**From:** [REDACTED]  
**To:** [A303 Stonehenge](#)  
**Subject:** Environment Agency Written Representations - Deadline 4 - A303 (Stonehenge) Amesbury to Berwick Down DCO  
**Date:** 21 June 2019 19:00:46  
**Attachments:** [REDACTED]

**Your Ref: TR010025**

**A303 (Stonehenge) Amesbury to Berwick Down scheme**  
**Environment Agency – Written Representations – Deadline 4**

# Written Representations

PROPOSED BORED TUNNEL - (WORK No. 1F)

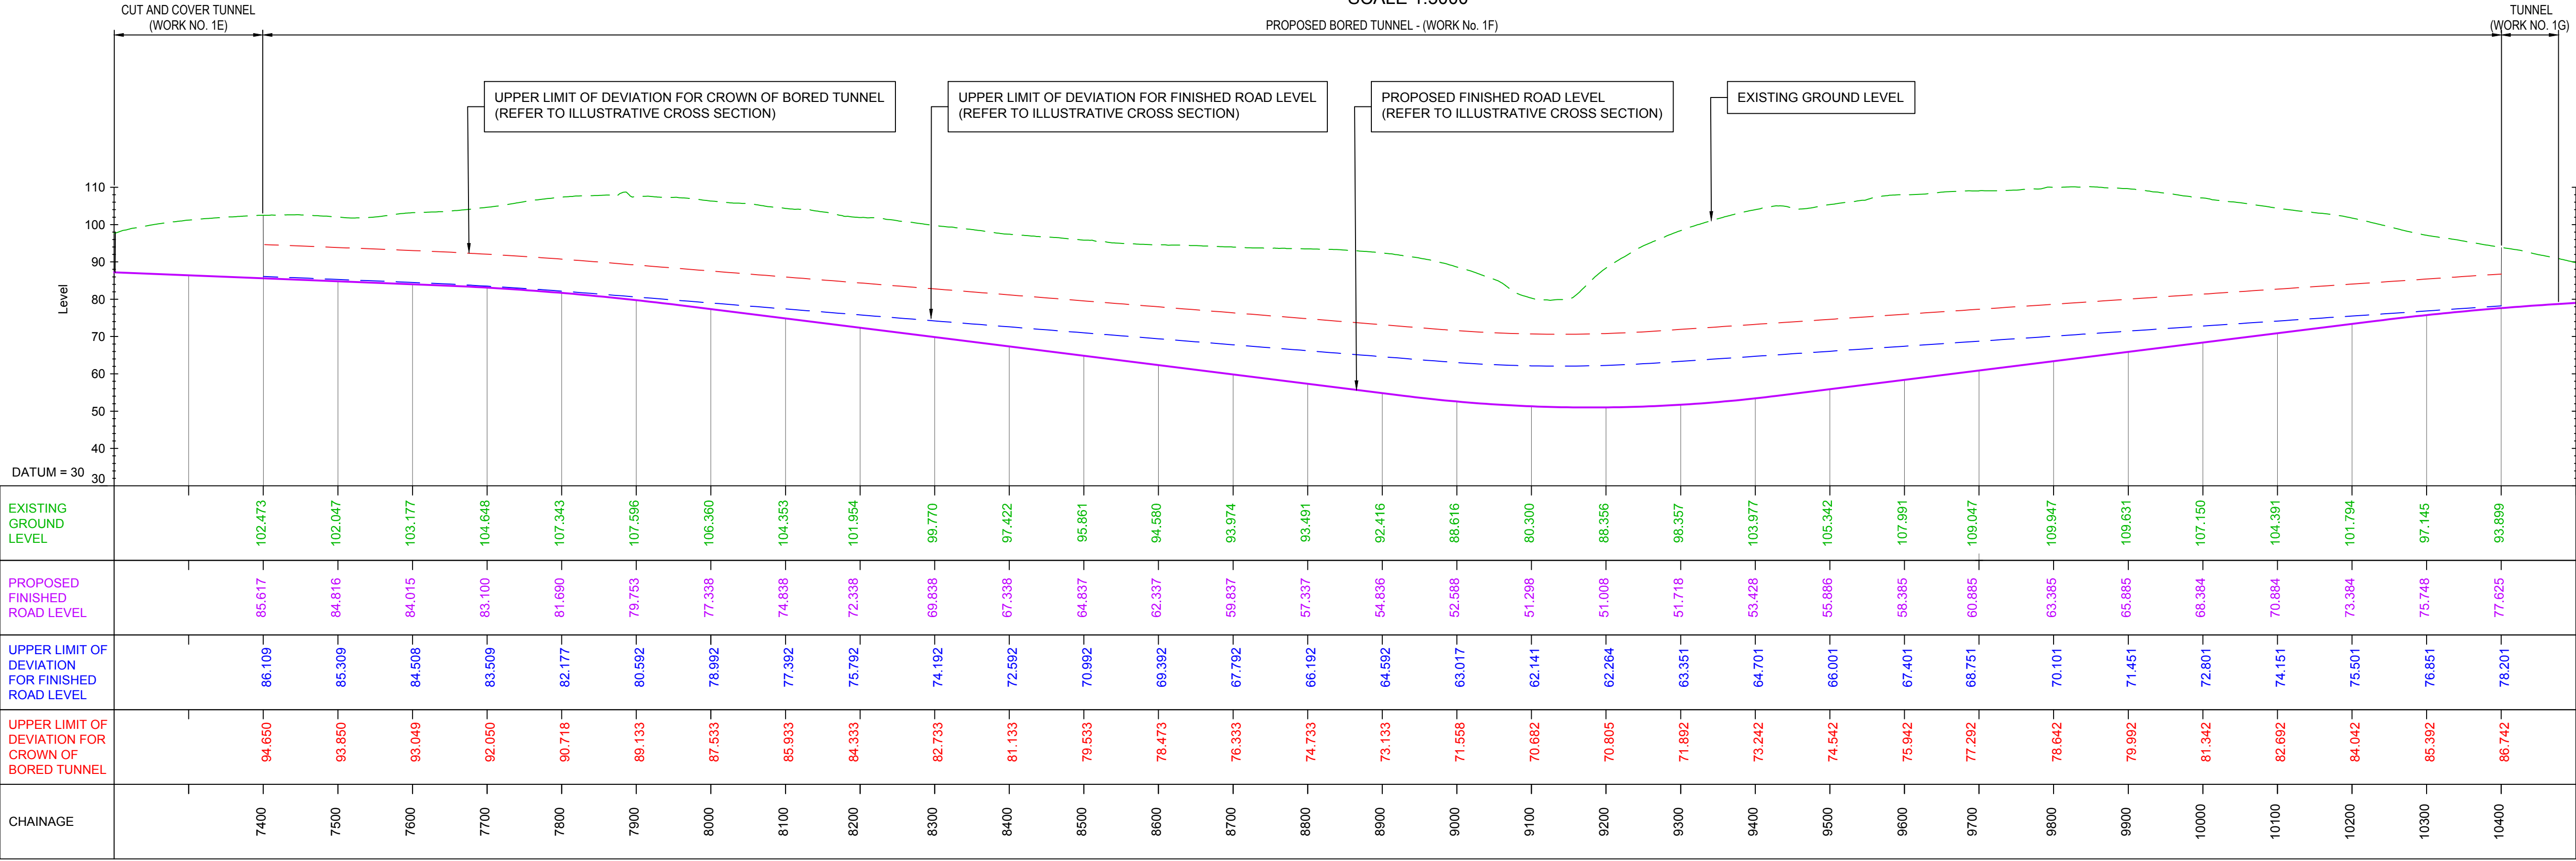
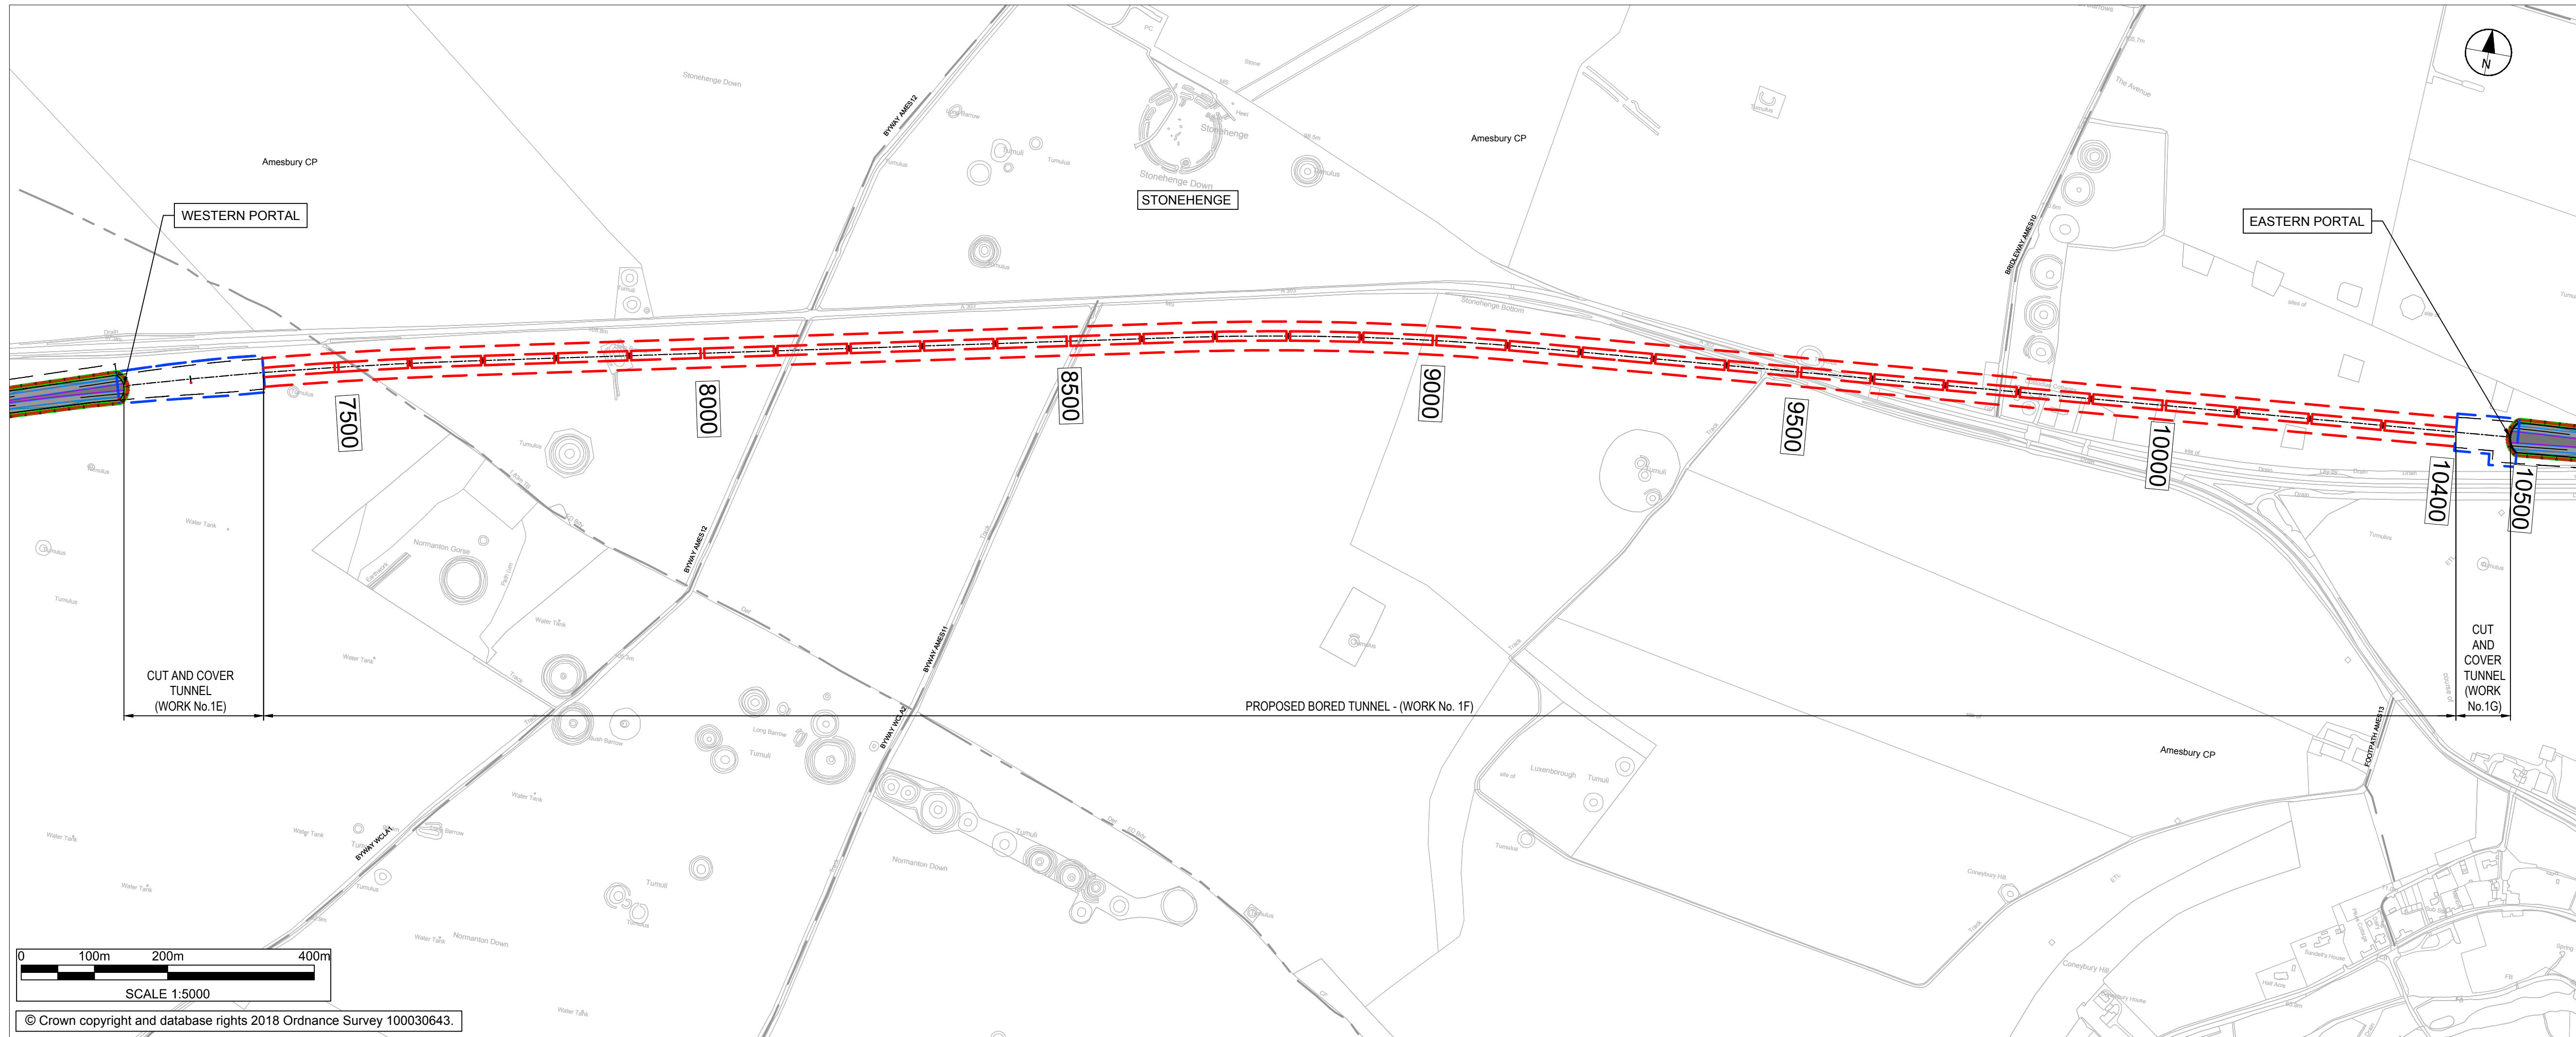
1.2.2 The Bored Tunnel Limits of Deviation Plan (TR010025-2.16 Rev P02) submitted with the DCO application indicates an upper limit for the crown of the tunnel at 70 mAOD at the lowest point of the tunnel - beneath Stonehenge Bottom - and no lower limit to its vertical alignment.

1.2.3 The groundwater risk assessment to date (most recently updated in *Implications of 2018 Ground Investigations to the Groundwater Risk Assessment, P04. AECOM, Mace, WSP, April 2019*) has assessed the impacts of an alignment where the crown, at its lowest point – beneath Stonehenge Bottom – is 55 mAOD. This assessment places the tunnel beneath the expected elevation of the Whitway Rock which is thought to act as a preferential flow horizon (although the presence of these and exact location has not been confirmed to date). Due to the risk of the tunnel impeding flow along this horizon should its alignment, design or construction methodology change, it is essential that any changes to the detailed design are adequately risk assessed. The EA should be consulted on any updated design and risk assessment and agreement reached with the EA regarding conclusions and any mitigation measures proposed.

1.2.4 We would welcome consultation with us before the proposed Limits of Deviation for the tunnel could be invoked.
